Please ask for: Nicola Moore
Email: nicola.moore@arun.gov.uk
Telephone: Ext 37944
Our Ref: LU/276/20/HH
Your Ref:
Date: 22nd October 2020

Application for Planning Permission for Works or Extension to a Dwelling

Development: Side Extension and 2 storey rear extension (Resubmission of previously approved LU/334/19/HH).
Location: Parkfield Worthing Road Littlehampton BN17 6SH

EXISTING FLOOR PLANS

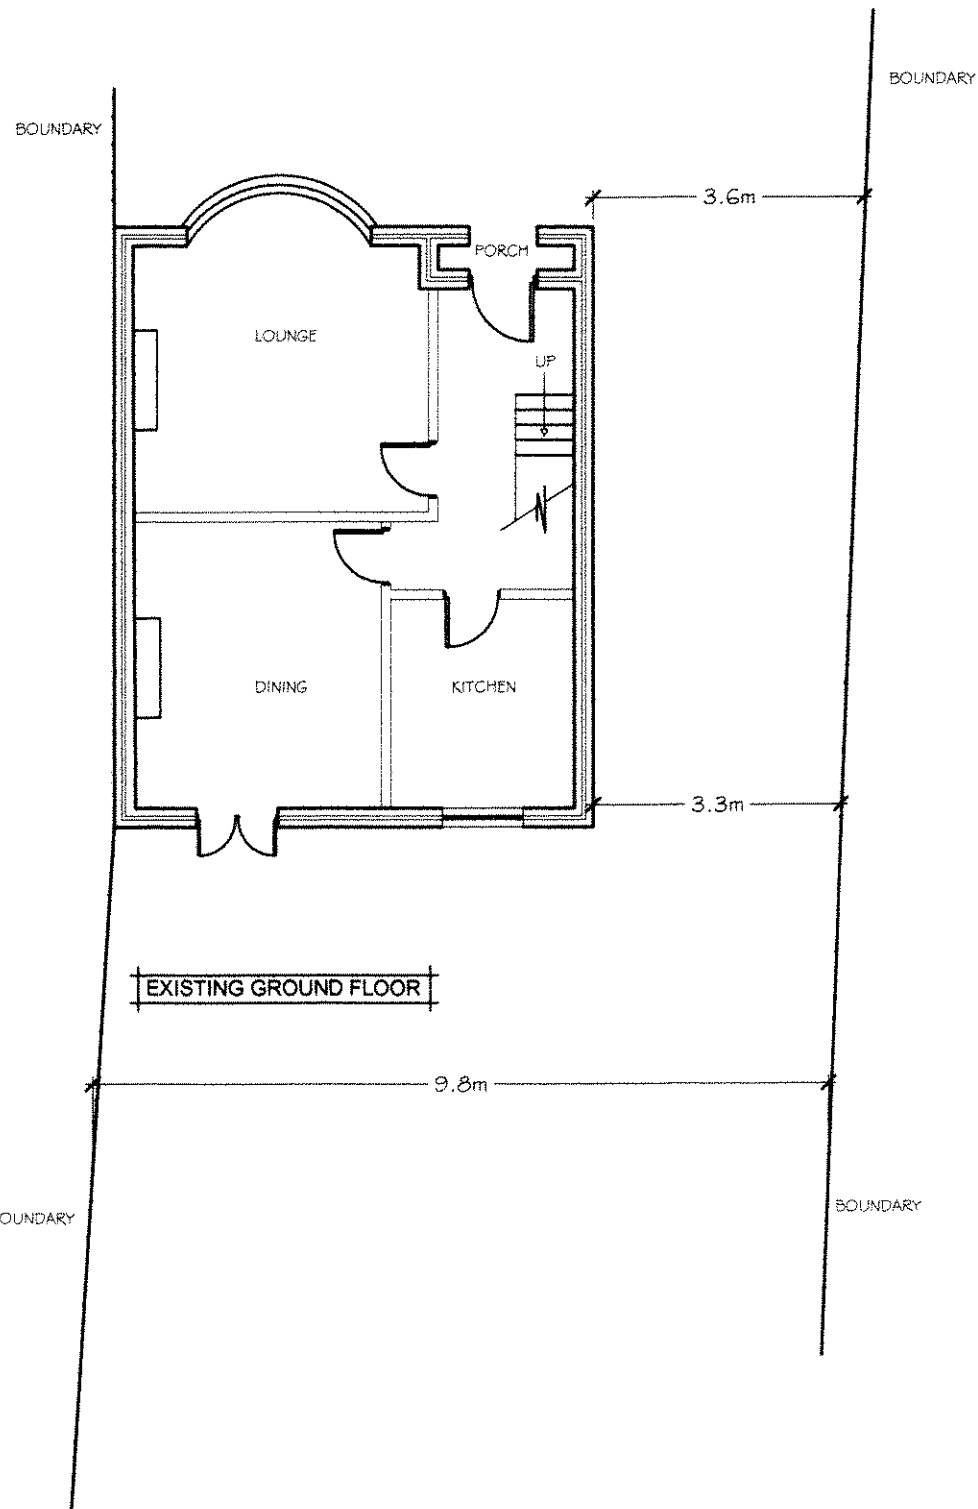
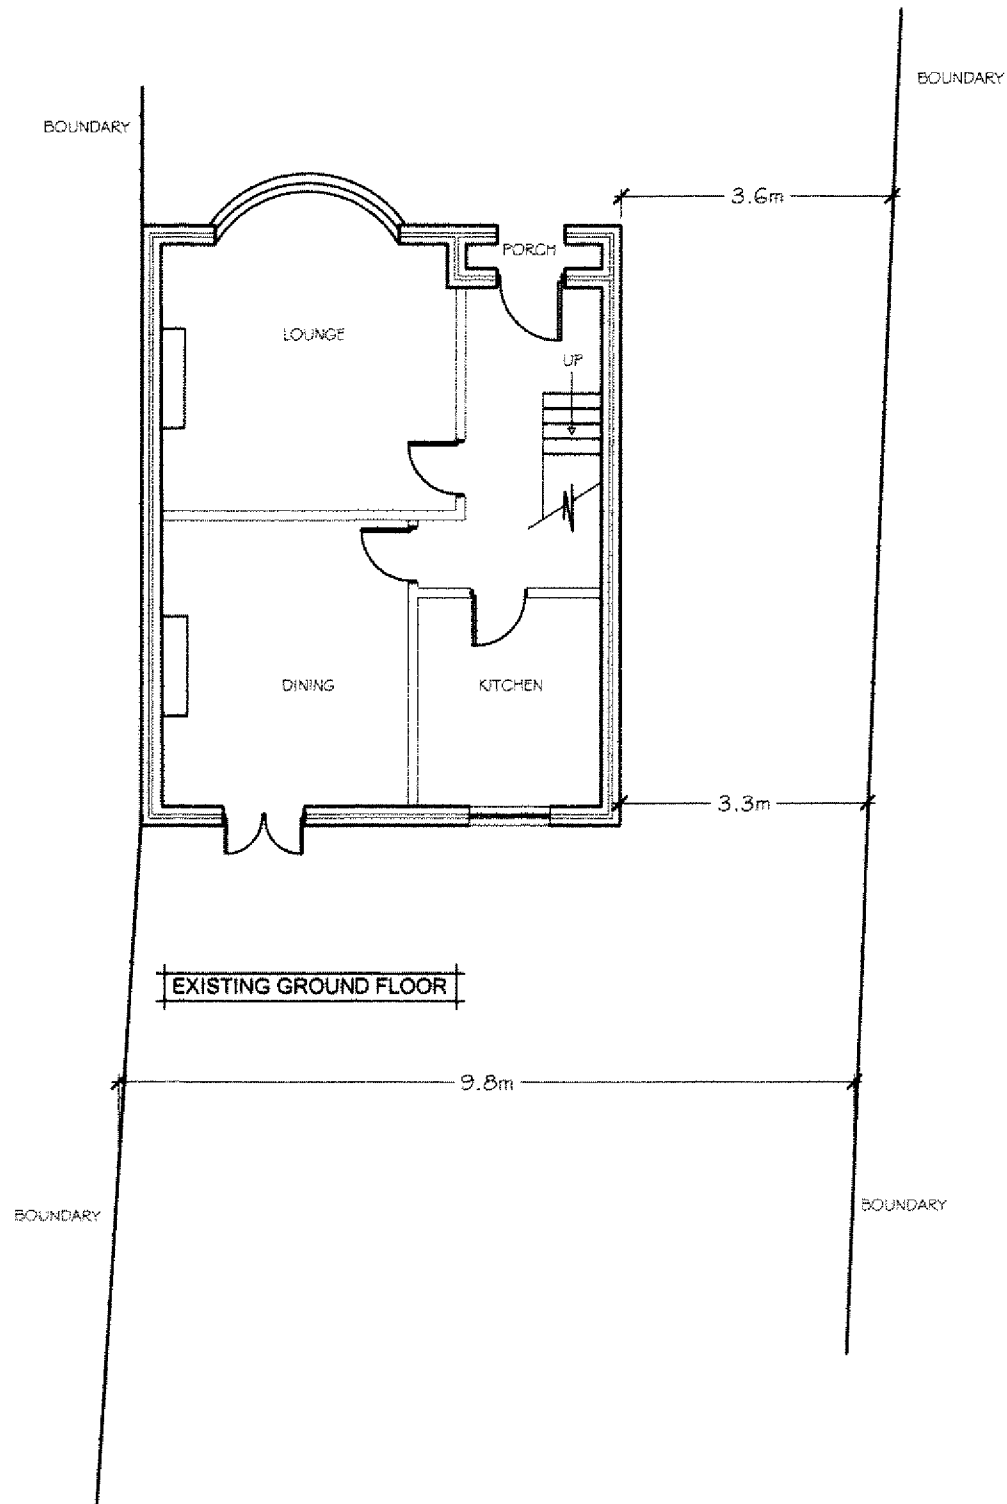
Please submit 1 electronic or 3 paper copies of clearly labelled existing floor plans at a scale of 1:50 or 1:100. Further details can be found in the Validation Requirements List.

PROPOSED SOUTH ELEVATION

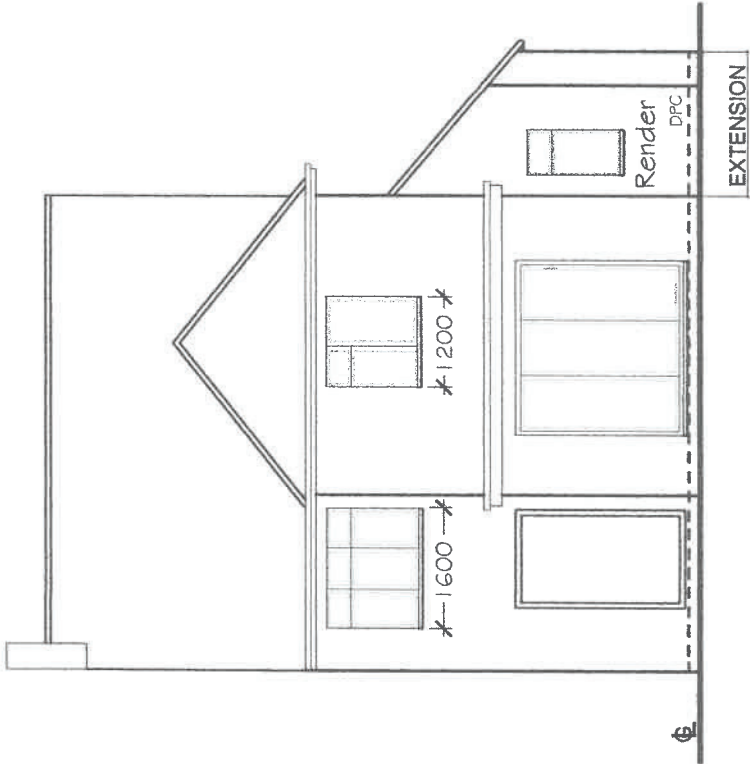
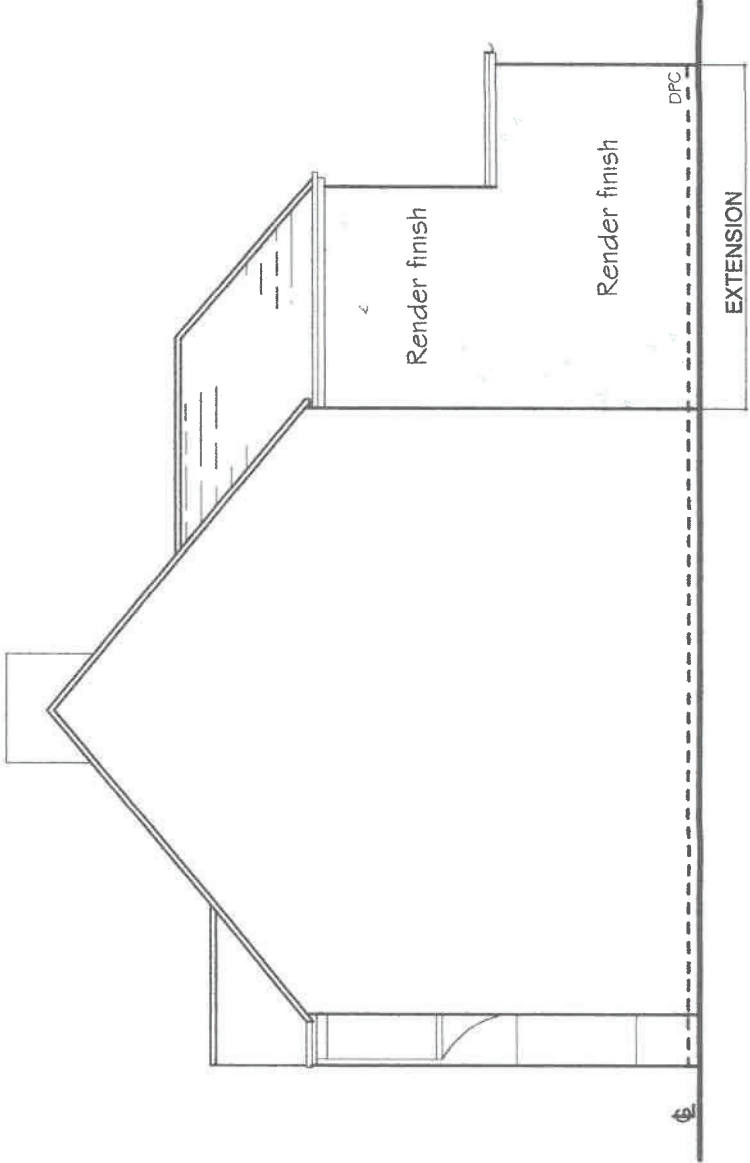
The first floor windows on the South Elevation measure 1.6m and 1.2m on drawing number 03 Proposed Elevations, and 1m and 1.2m on drawing number 04 Proposed Floor Plans. Please check the measurements, amend accordingly and resubmit.

DRAWING
BLOCK PLAN

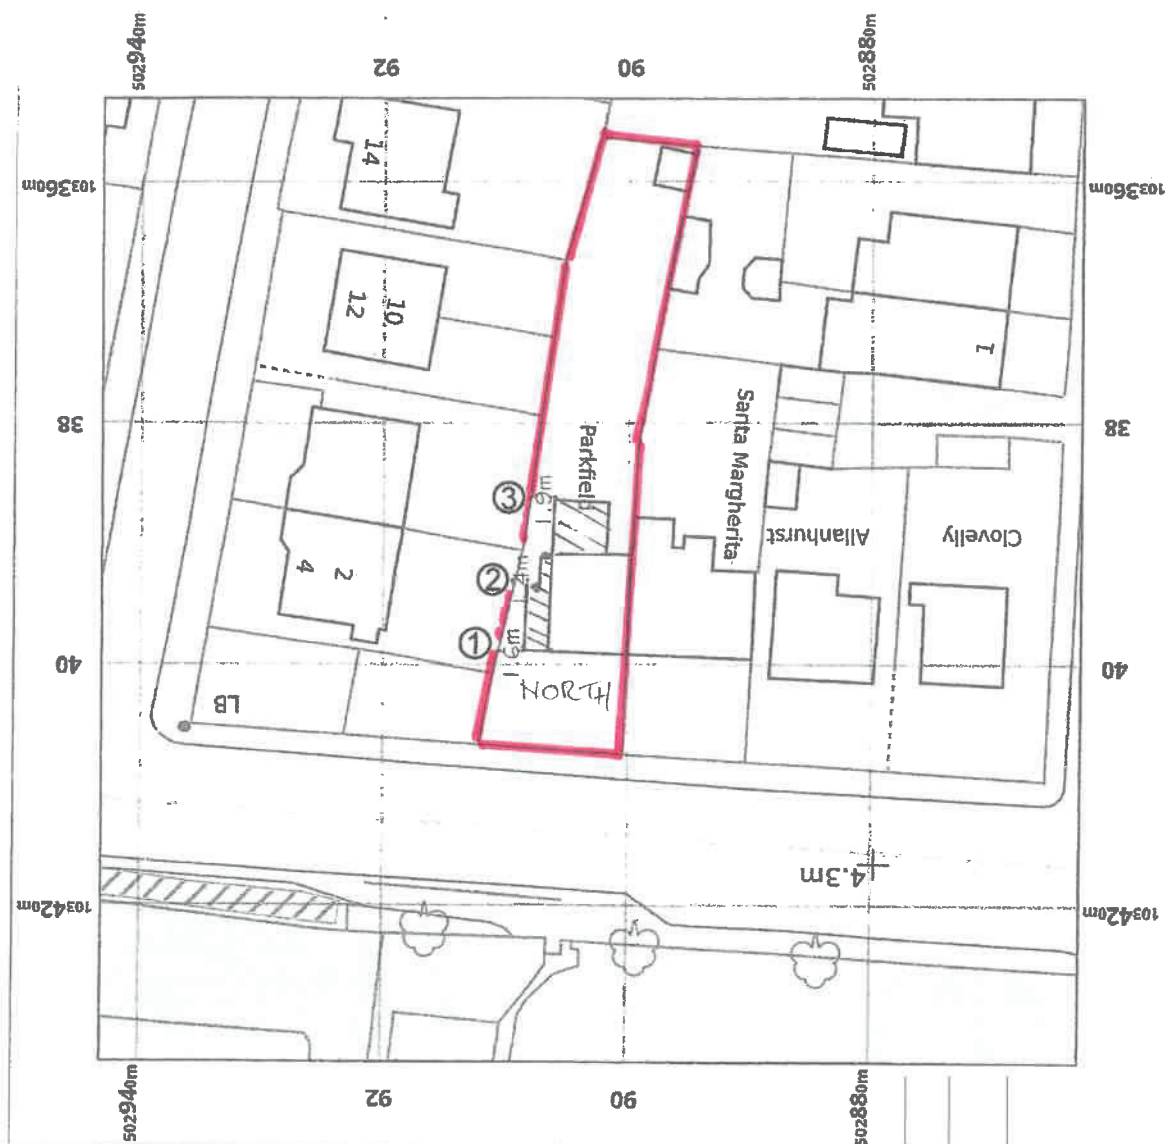
Please include written dimensions to boundaries and re submit.
CIL Additional Information Form
